Town & Country Planning Act 1990 (as amended)
Town & country Planning (Development Management Procedure) (England) Order 2015 - Article
5
Application for Outline Consent

Development Outline application with some matters reserved for the erection of 55 No. dwellings, access arrangements, sustainable drainage measures, public open space, landscaping & all other associated works (resubmission following AL/115/17/OUT). This application is a Departure from the Development Plan.

Location Wings Nursery Lidsey Road Woodgate

Street Elevation

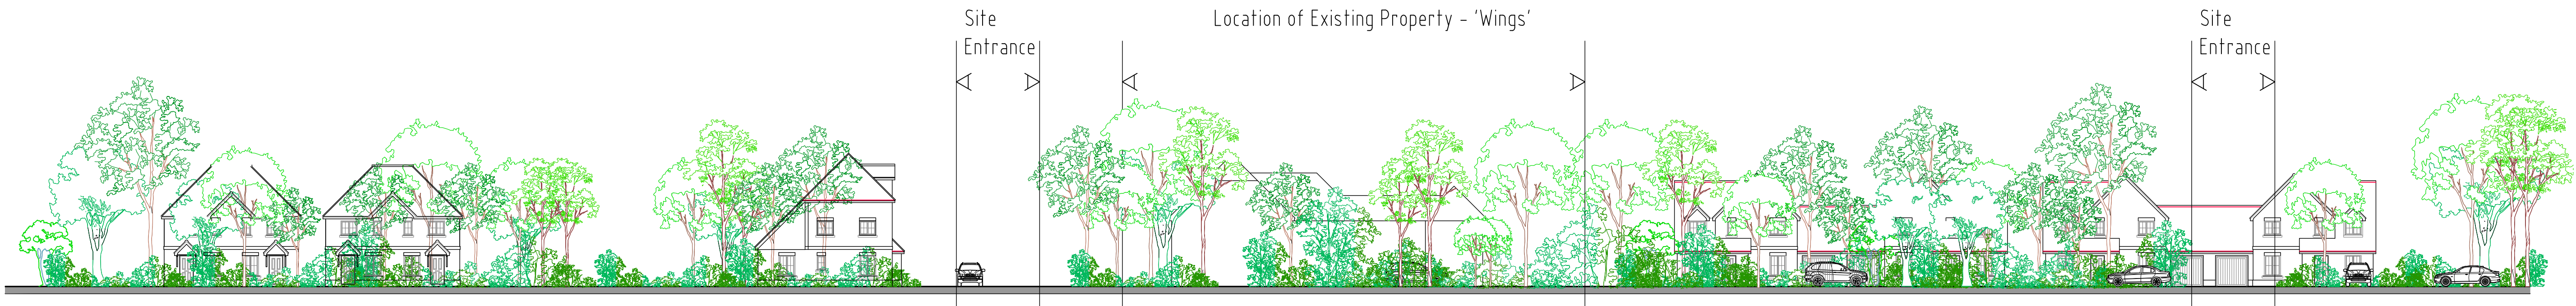
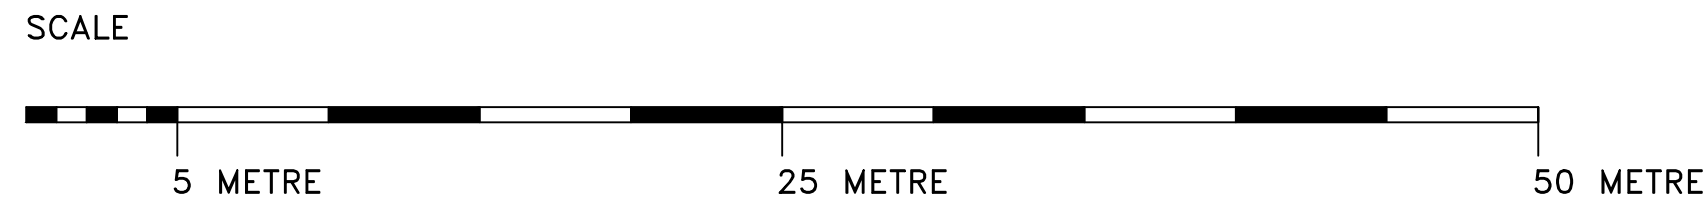
On the street scene plan, please clearly show both proposed access points.
